RE: **Broadstone Highlands North Block**
Conceptual Grading and Drainage Plan
Engineer's Stamp Date: 8/31/17
Hydrology File: K15D034A

Based on the information provided in the submittal received on 9/1/17 the above-referenced Conceptual Grading and Drainage Plan (not for construction) can be approved for Site Plan for Building Permit with the following conditions:

DRAINAGE
MANAGEMENT PLAN

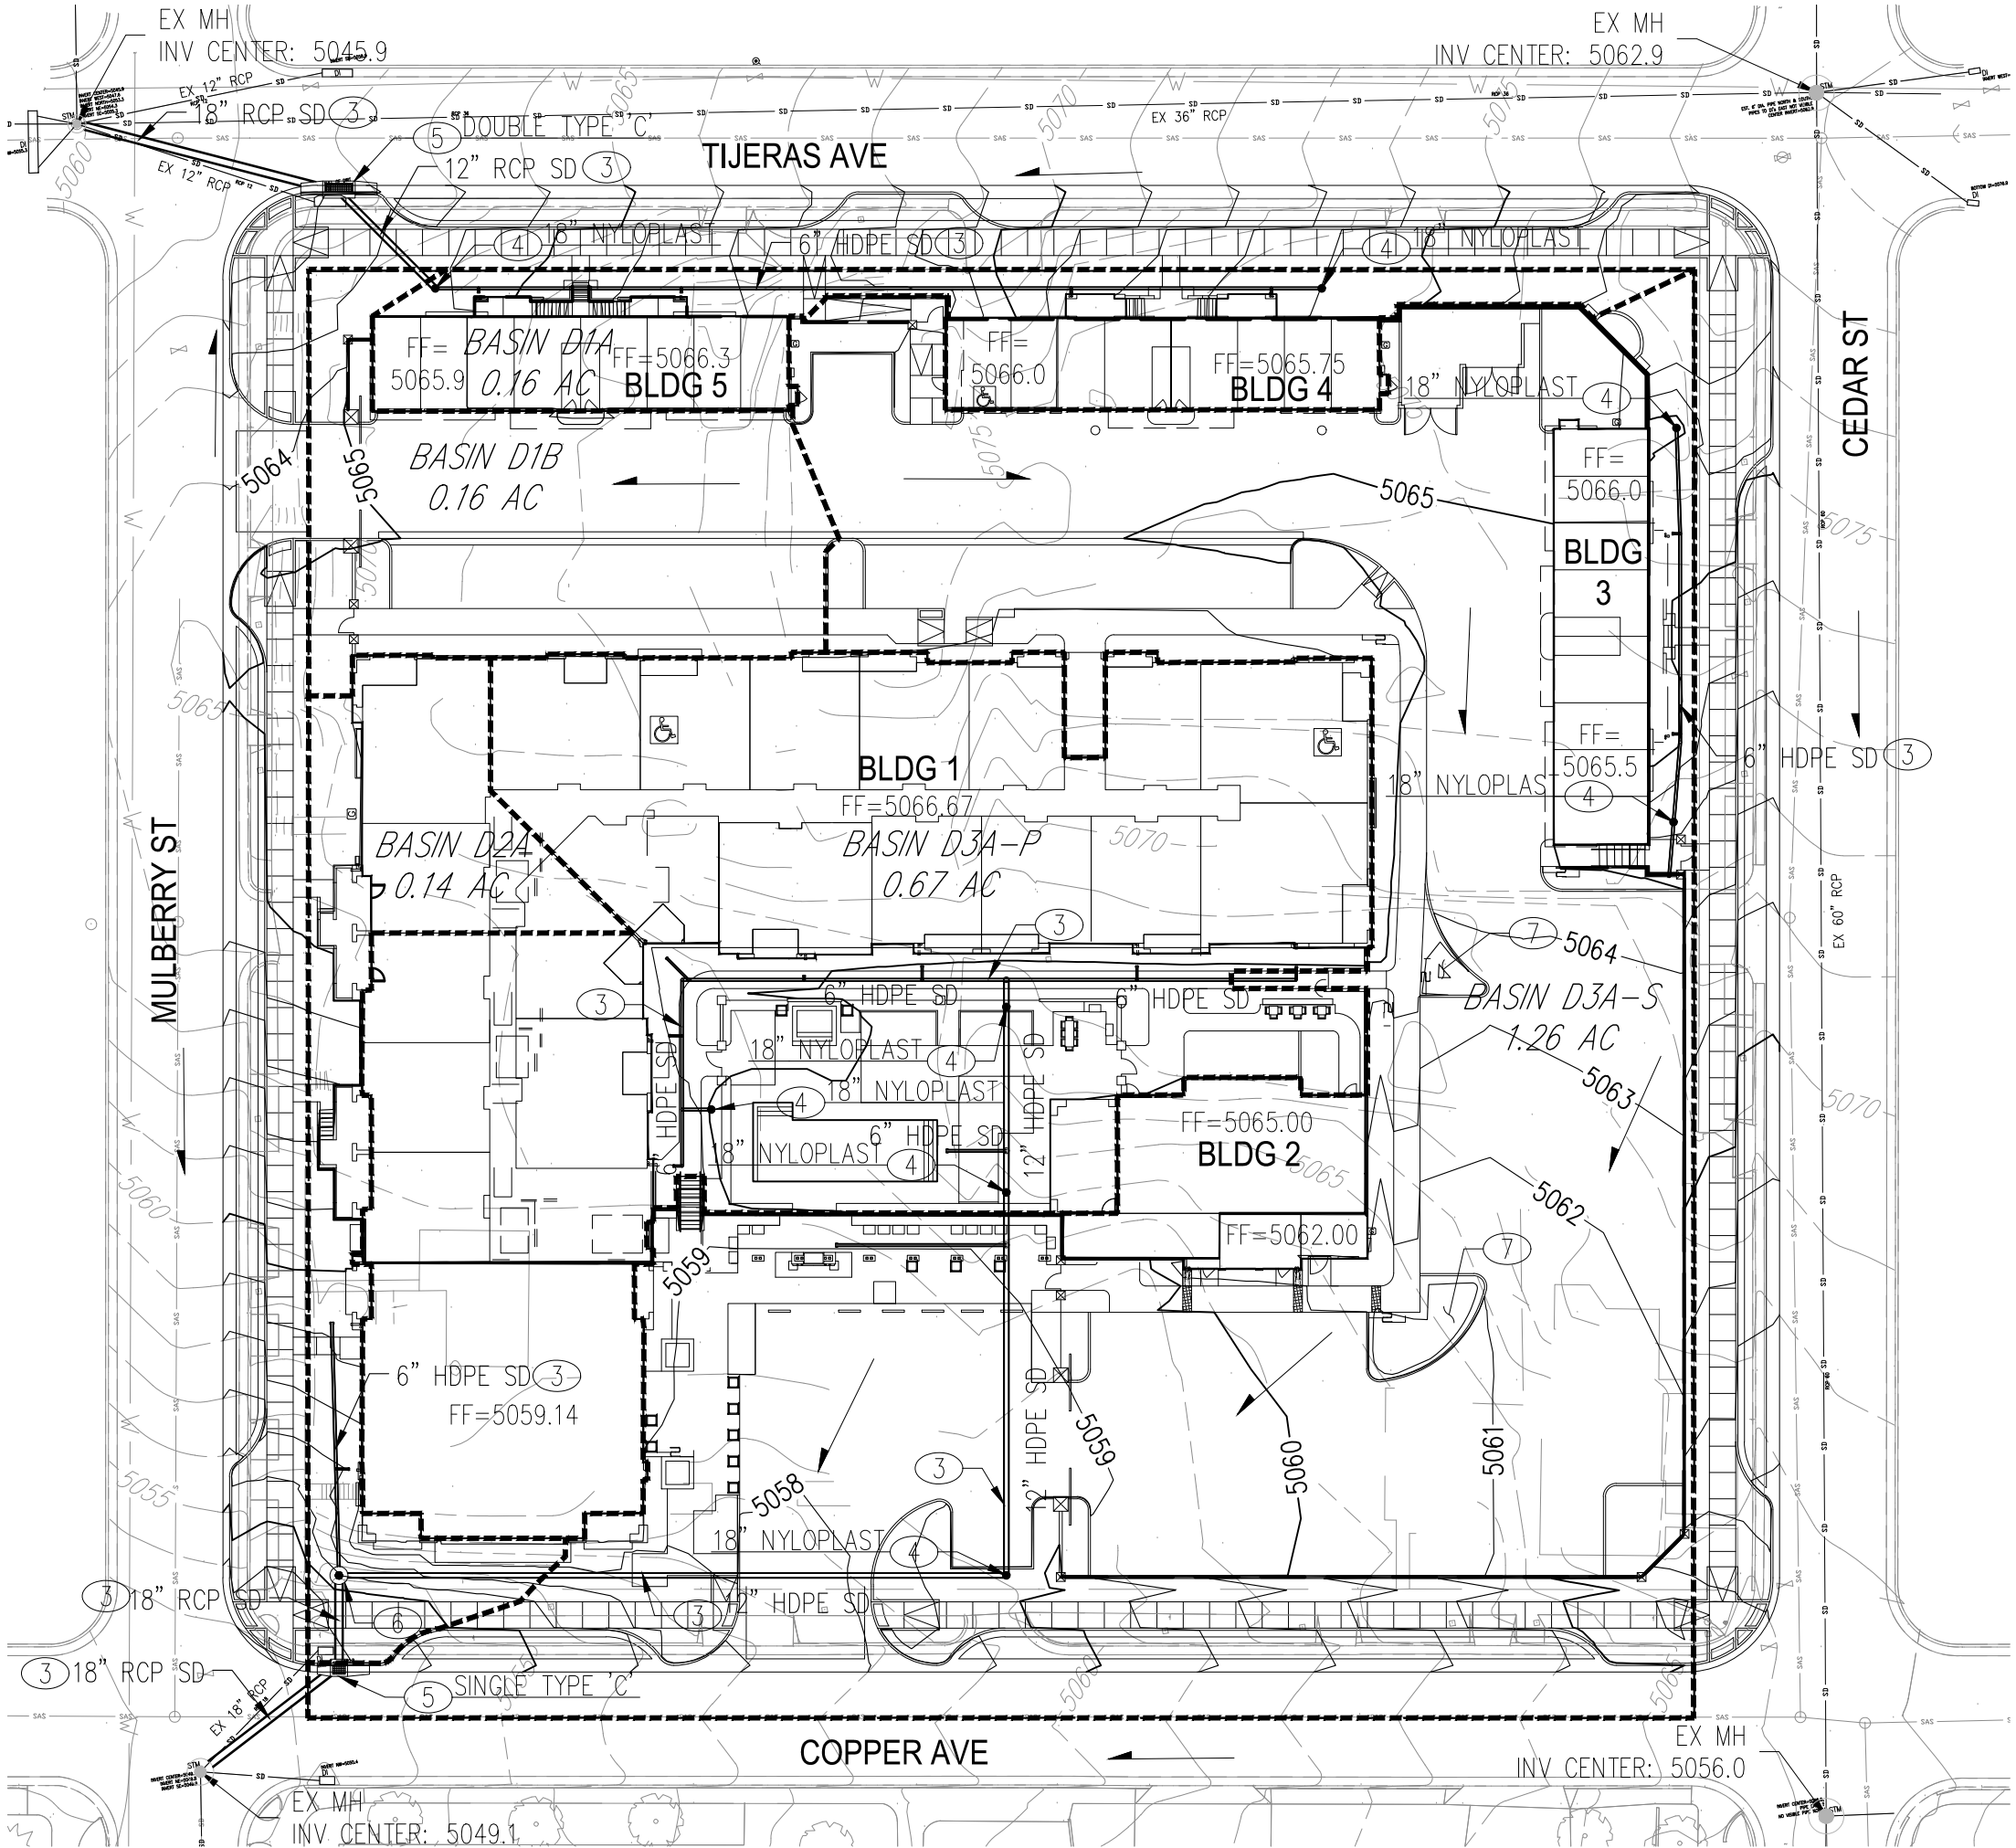
1. Provide multiple section views of the retaining walls along Tijeras, Cedar, and Copper to ensure that adjacent properties and ROW are not damaged or constrained in their use by these walls (per DPM Ch.22.5.B). These sections views should show the following:
 - a. Wall and footer, including dimensions and retained height.
 - b. ROW and easements.
 - c. Underground utilities and their trenching prisms.
 - d. Existing structures, such as sidewalk, curb and gutter, and roadway.
 - e. Temporary slope during construction.
2. Depending on the above potential conflicts, the following will be required:
 - a. Any private encroachment into the public ROW by the footer, retaining wall or any structure will require a revocable permit.

- b. Any private encroachment into public easements by the footer, retaining wall or any structure will require an encroachment agreement.
3. Provide size/type information for all ROW drainage improvements.
4. For the drop inlet replacement at the northwest corner, the 12" storm drain line will need to be replaced to the manhole with an 18" storm drain line, similar to what's being done at the southwest corner inlet.
5. Construction plans for work in the public ROW will be to be submitted to DRC for review.
6. Include note on grading plan: "No construction permitted in the public ROW without an approved Work Order."
7. Payment of the Fee in Lieu (Amount = 2,662CF x \$8/CF) for the required first flush volume must be made.
